**Consultation Response from KC,
Trees**

2026/91690 Land adj, 7, Tommy Lane, Linthwaite, Huddersfield, HD7 5SQ

**Demolition of existing stable block and erection of detached dwelling with detached garage
and associated works**

Date Responded: 08/07/2026

PROPOSED SITE LAYOUT PLAN
1 : 250

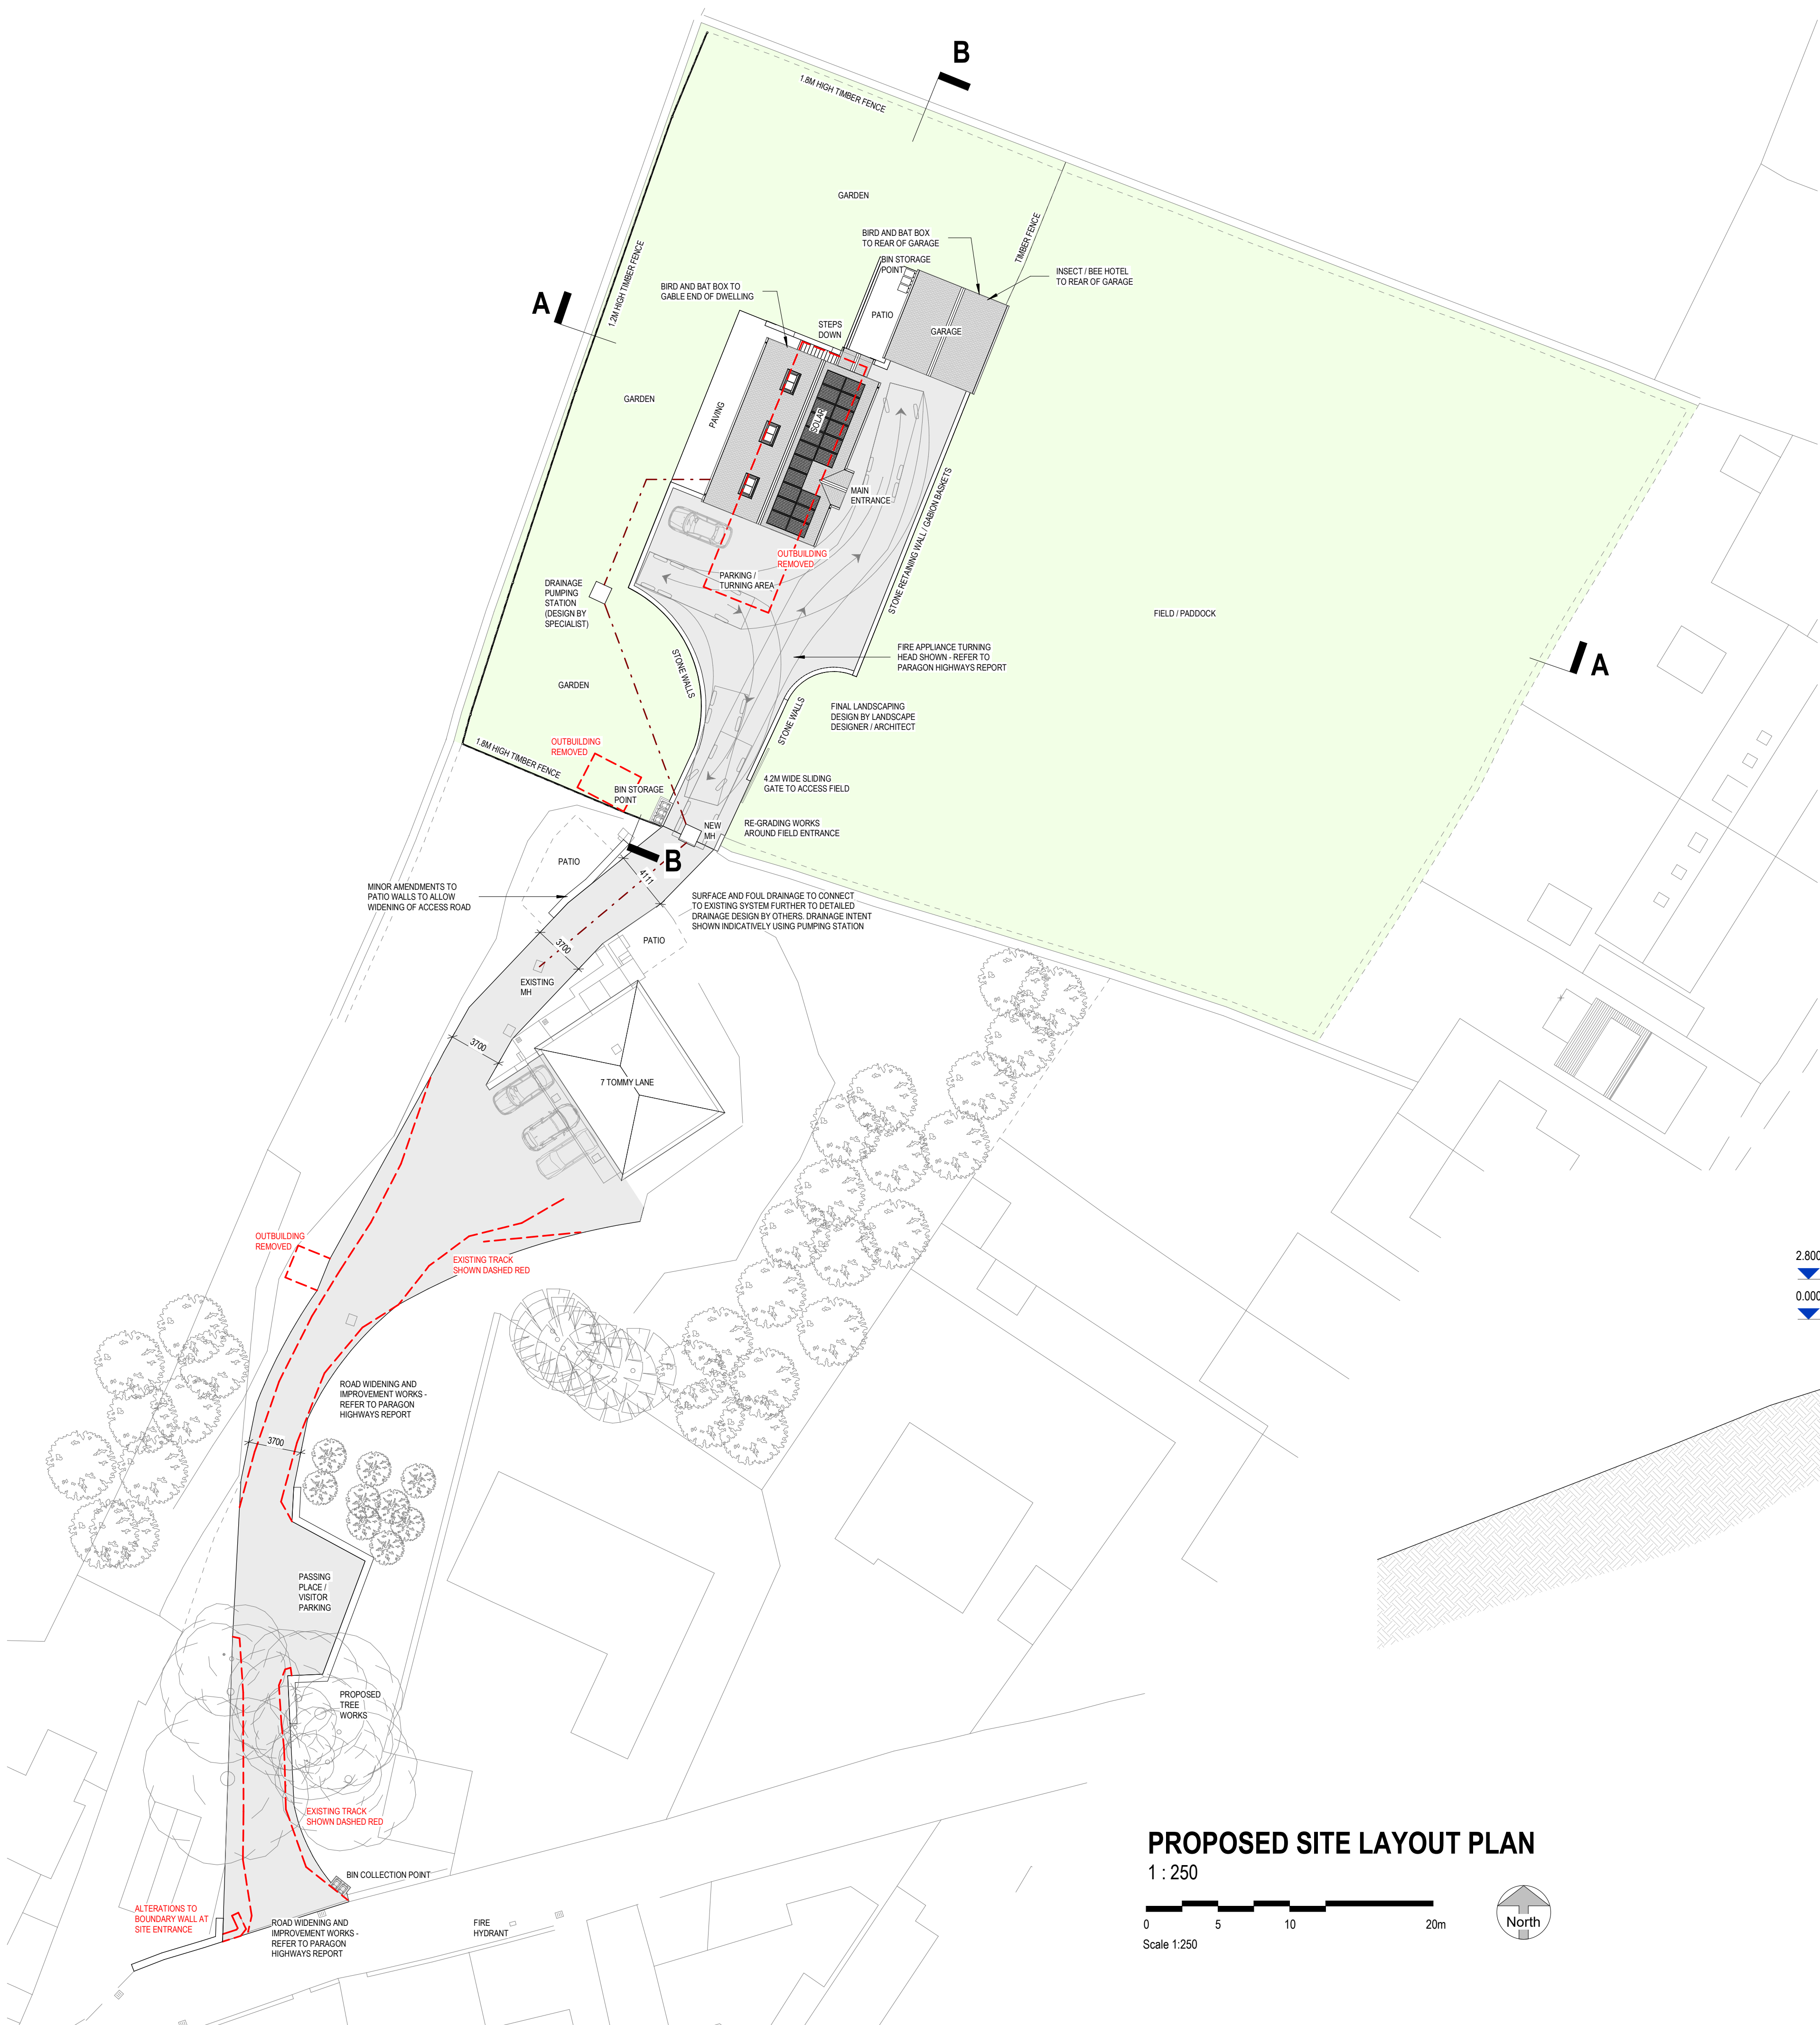
Regarding the trees at the entrance, It appears some tree removal would be required to facilitate the widening of the access road and location of the passing place/visitor parking.

All of the trees in this location have either previously been heavily pruned/are dead or dying/ or are poorly formed which would make them all category C or U trees and would not warrant further protection by a TPO. Therefore, their removal would be deemed acceptable to facilitate the development.

Mitigation planting would be required within the site to offset the environmental impact of these trees being removed, however this can be secured via a condition in the form of a landscape plan.
